Charlotte Department of Transportation

Memorandum

Subject: Rezoning Petition 08-078: Located on the north side of East Mallard
Creek Church Road between Stone Quarry
Road and Bonnie Cone Lane

**REZONING
SITE PLAN
REZONING PETITION
2008-078**

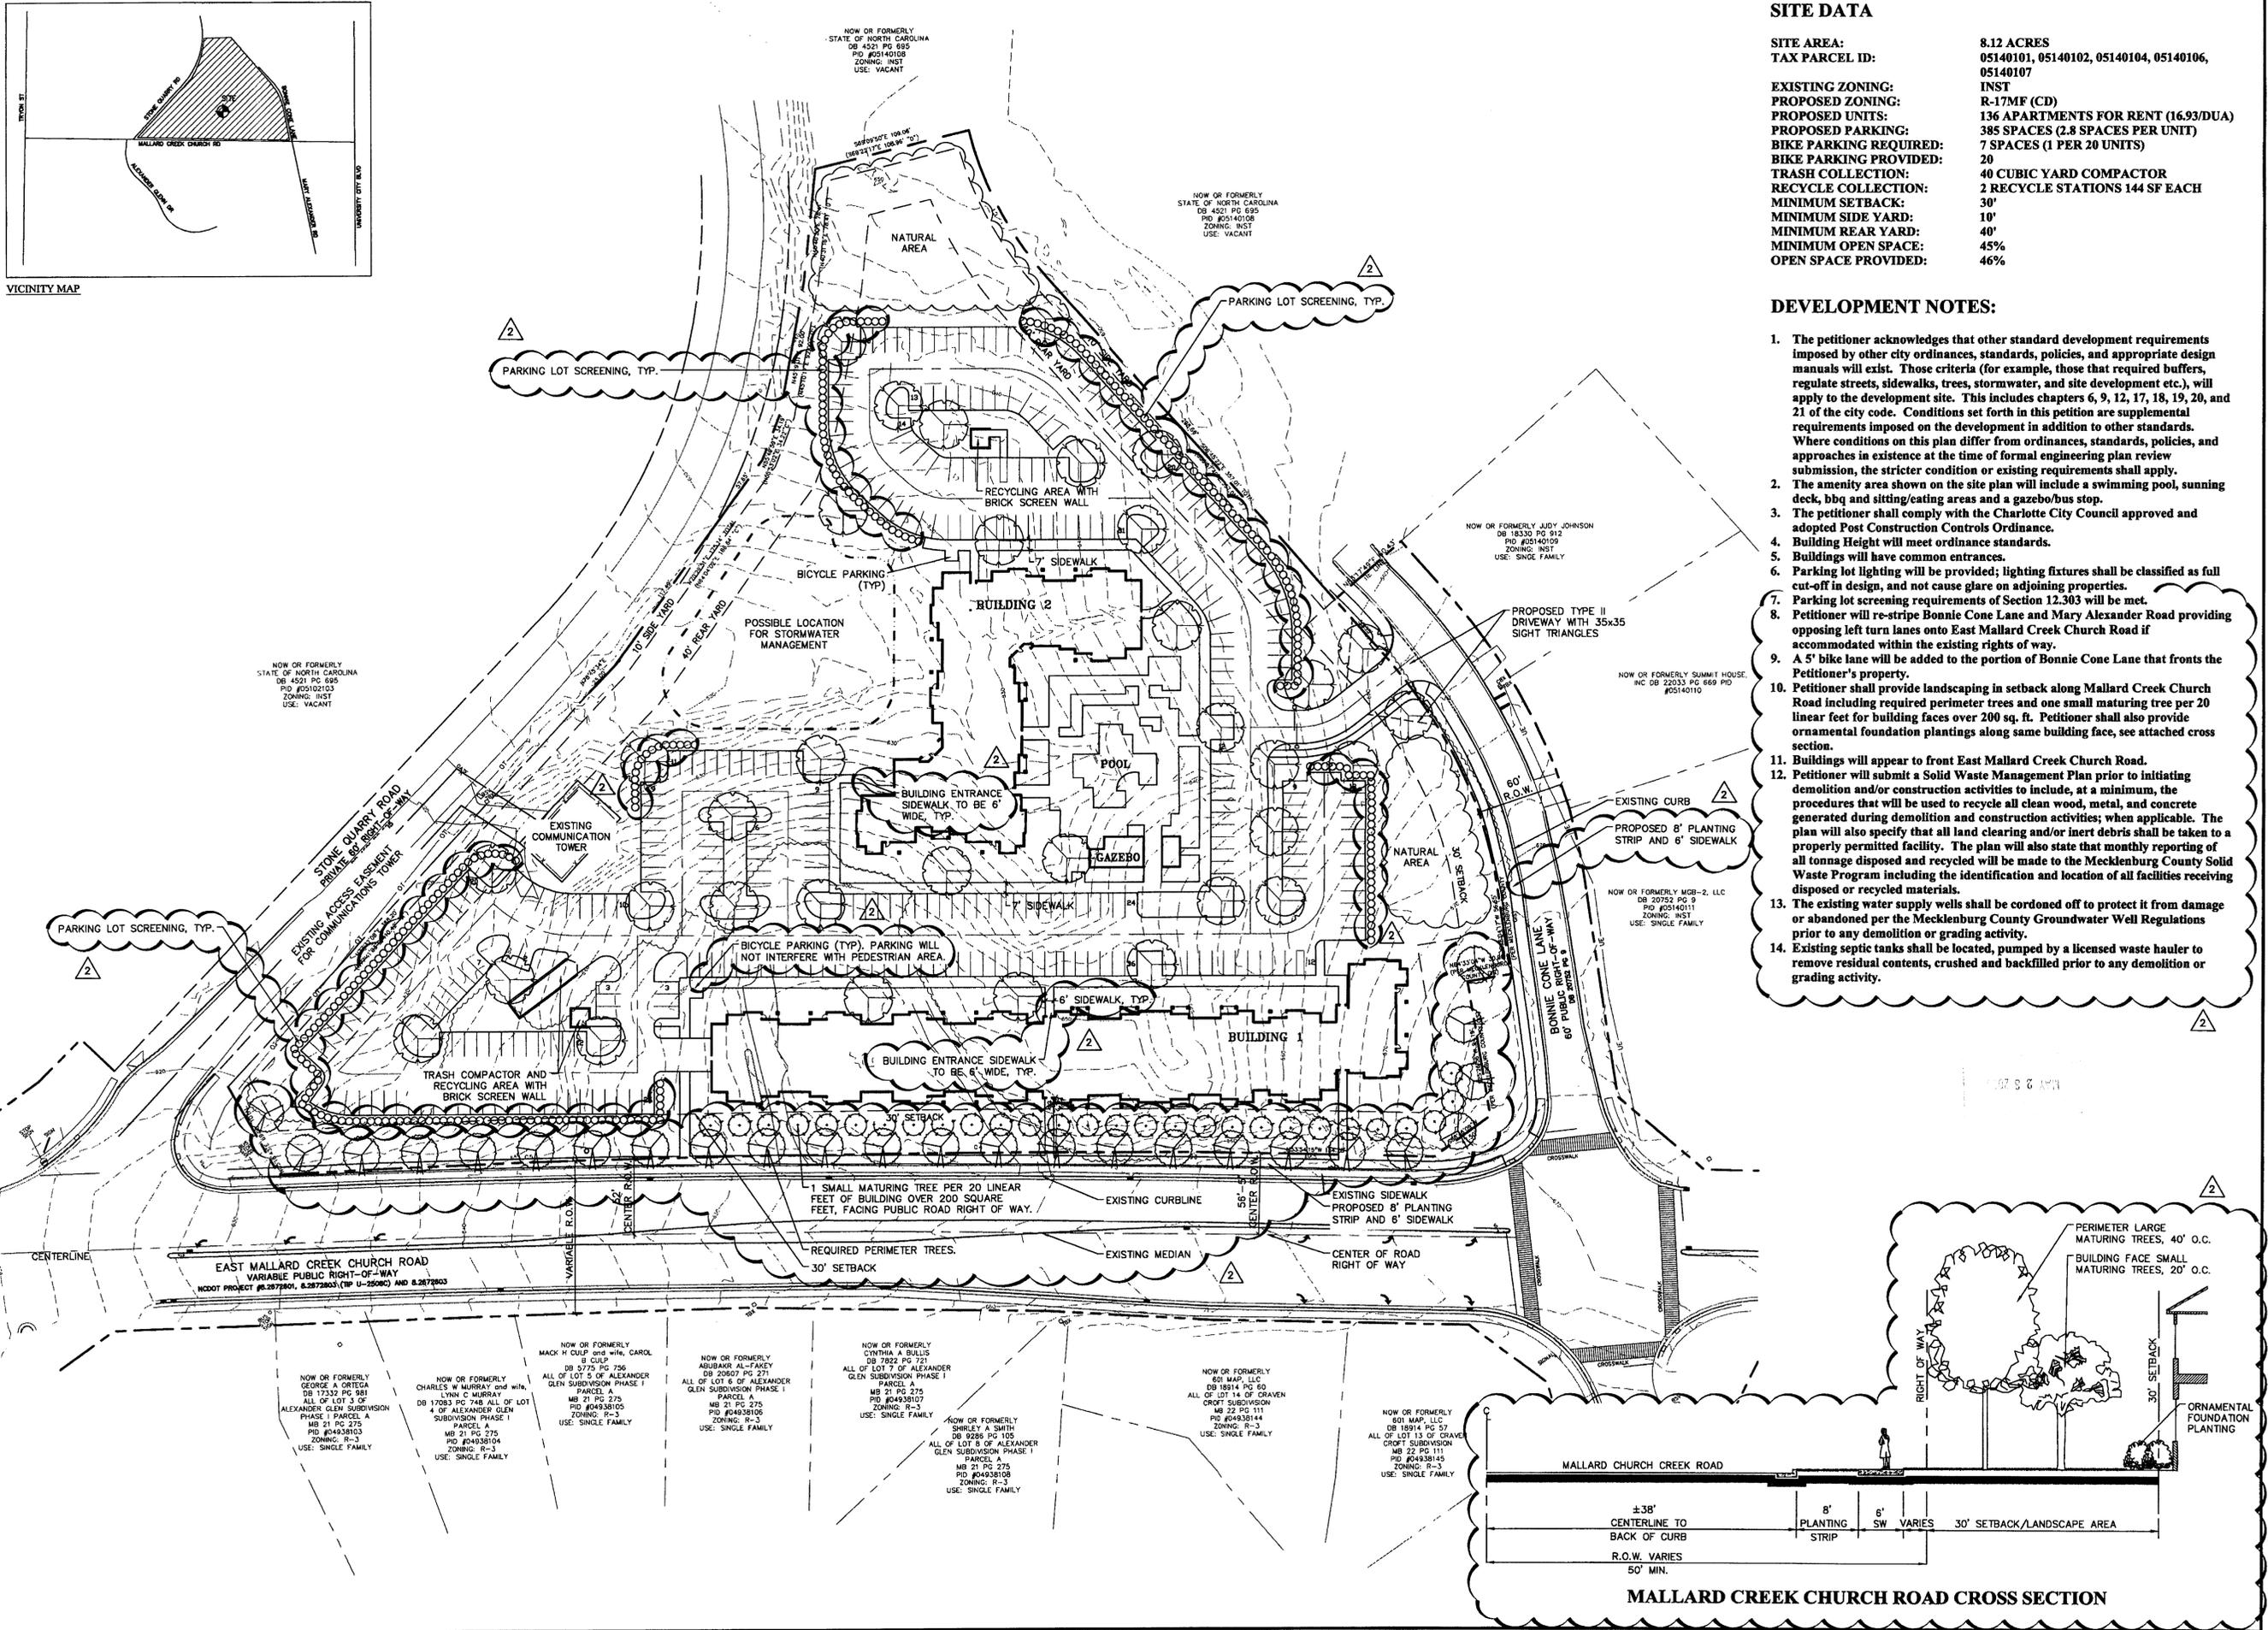
1. According to the City of Charlotte's Driveway Regulations, CDOT has the authority to regulate/approve all private street/driveway and public street connections to the right-of-way of a street under the regulatory jurisdiction of the City of Charlotte. CDOT has determined that a left-turn lane is necessary to serve the traffic using the existing public street for this site. The engineering design and construction of the left-turn lane is the responsibility of the owner, and shall be performed by a professional engineer registered in the State of North Carolina who has roadway-design experience. CDOT will only approve the proposed private driveway connection(s) provided that a left-turn lane is constructed on Bonnie Cone Lane

turning onto Mallard Creek Church Road. To eliminate the potential for left-turn conflicts, a left-turn lane must also be constructed on Mary Alexander Road that directly aligns with the one on Bonnie Cone Lane. We recommend the rezoning plan reflect the design of these required left-turn lanes prior to submittal/approval of the private driveway connection(s). These roadway improvements are required to meet the traffic demands of the proposed development. The left-turn lanes should be designed with a minimum 150 feet of storage and to NCDOT left-turn lane design standards.

2. As shown on the site plan, the driveway access location on Bonnie Cone Lane requires that additional right-of-way be acquired and dedicated to the City of Charlotte. Alternately, the driveway location can be modified so that the acquisition of additional right-of-way is not necessary.

3. The addition of this many residential units primarily marketed to students and within reasonable cycling distance of UNC-Charlotte's main campus warrants the addition of bicycle lanes, especially since Bonnie Cone Lane aligns with Mary Alexander Road via a signal. According to the adopted Urban Street Design Guidelines (USDG) Mary Alexander Road is classified as an Avenue. With this proposed development, Bonnie Cone Road will also be classified as an extension of that same Avenue. Avenues should include 5' directional bicycle lanes. With the widening of Bonnie Cone Lane to provide the required left-turn lane, it is requested that the improvements also include bicycle lanes.

4. An 8-foot planting strip and 6-foot sidewalk needs to be provided along the public right-of-way for Bonnie Cone Lane, as measured from the new curb line.

5. Driveway access to Stone Quarry Road is shown on the site plan. This section of Stone Quarry Road is a private street. Either additional right-of-way is acquired and dedicated to the City of Charlotte to accommodate the driveway, an easement is obtained from the adjacent property owner, or the access needs to be removed from the site plan. If it is decided to acquire/dedicate the additional right-of-way for Stone Quarry Road, it needs to be extended just beyond the access point to create a T-intersection similar to that requested for Bonnie Cone Lane and the existing gates/barricades moved to that location.

6. An access easement needs to provide ingress/egress for the maintenance of the existing communication tower and be shown on the plans.
